RE: RESPONSE TO BARNSELY METROPOLITAN BOROUGH COUNCIL COMMENTS

Enzygo Ltd produced a Flood Risk Assessment (FRA) during November 2019 (Document Ref. CRM.1122.003.HY.R.001.A).

Barnsley Metropolitan Borough Council (BMCC) have reviewed the FRA and provided comments in relation to the planning application (Reference WA/2019/1117). A copy of the letter is included in Appendix 1.

Outline planning application for a residential development of up to 107 dwellings including internal circulation roads, structural planting and landscaping, an attenuation basin, a children's play area and a footpath. All matters reserved except the location of the vehicular access.

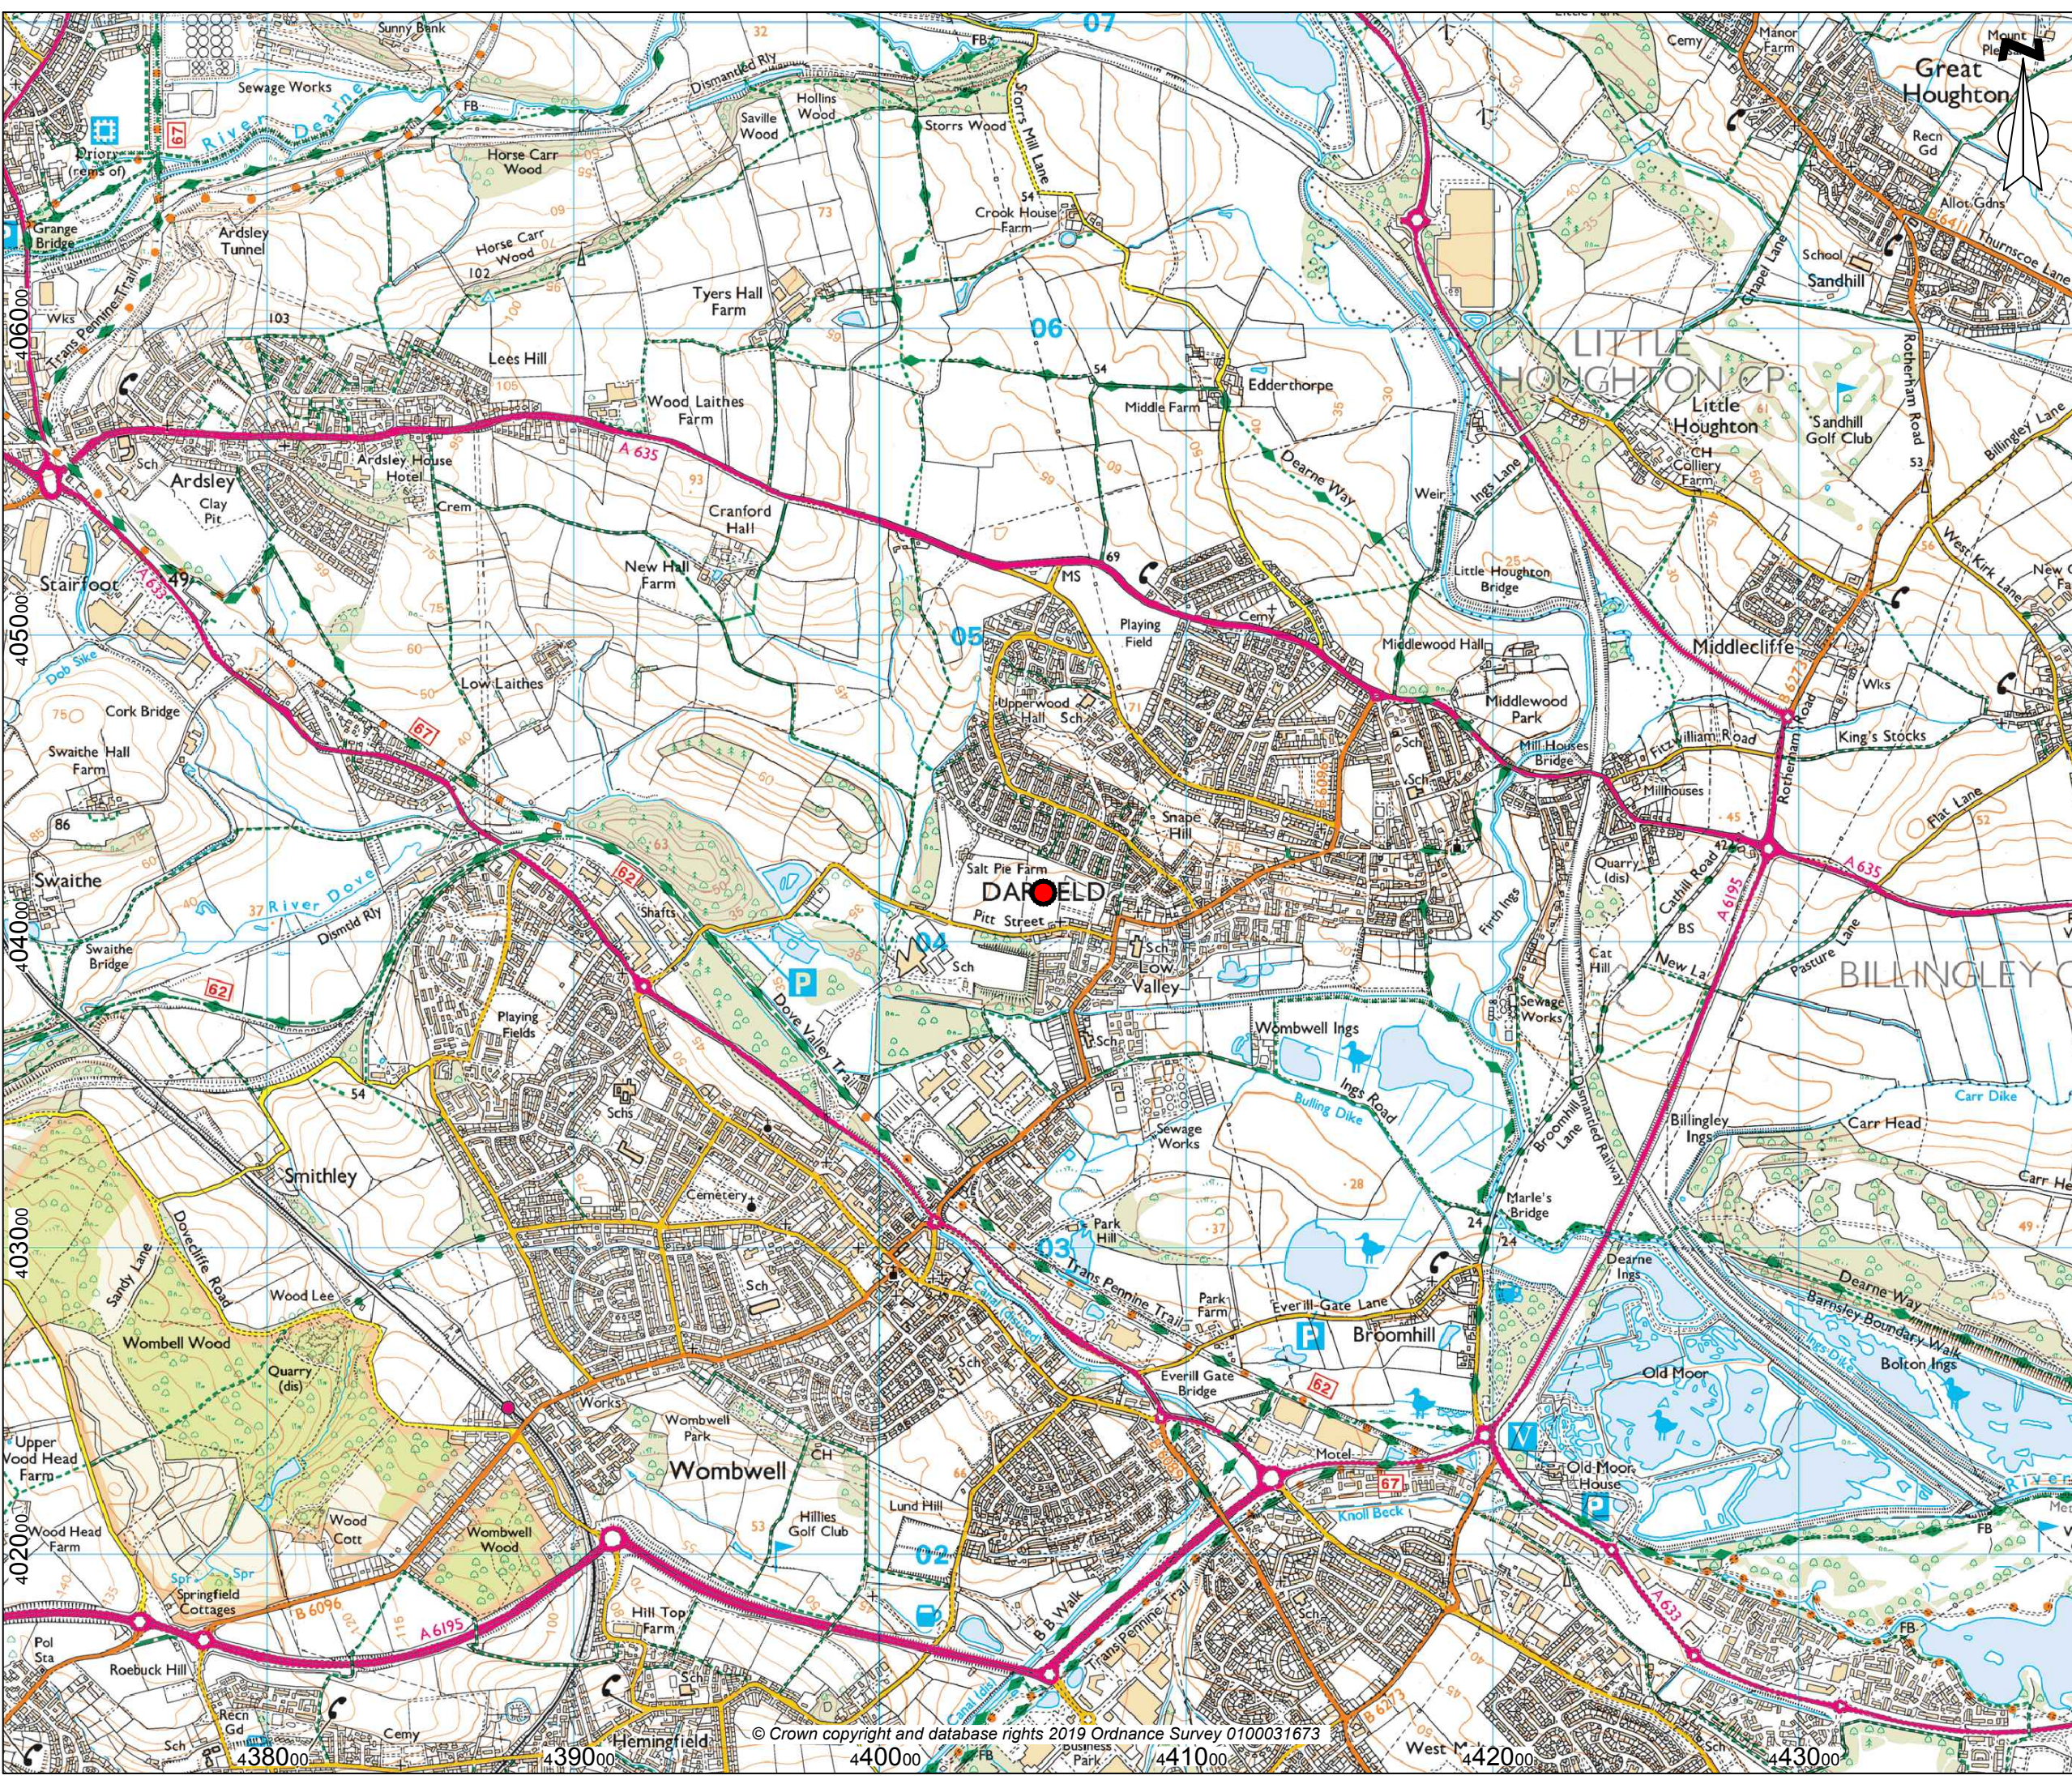
On the previous Pre-Application, I expressed concern regarding the drainage of this site. This application is unclear regarding the drainage of this site, with the application stating surface water to "main sewer", but the attached plans aren't clear on the final outfall. This site has caused flooding to the surrounding area in the past, so Surface water drainage details need to be determined at an early stage.

The foul and surface water systems would be discharged in separate systems. The foul water would discharge to the public combined sewer within Pitt Street. The surface water would discharge either to the surface water sewer within George Street to the east of the Site or to the surface water sewer located to the north of the Site. This has been agreed with Yorkshire Water at 5l/s subject to soakaway testing (Appendix 2). This is indicated on the indicative drainage drawing (Appendix 3).
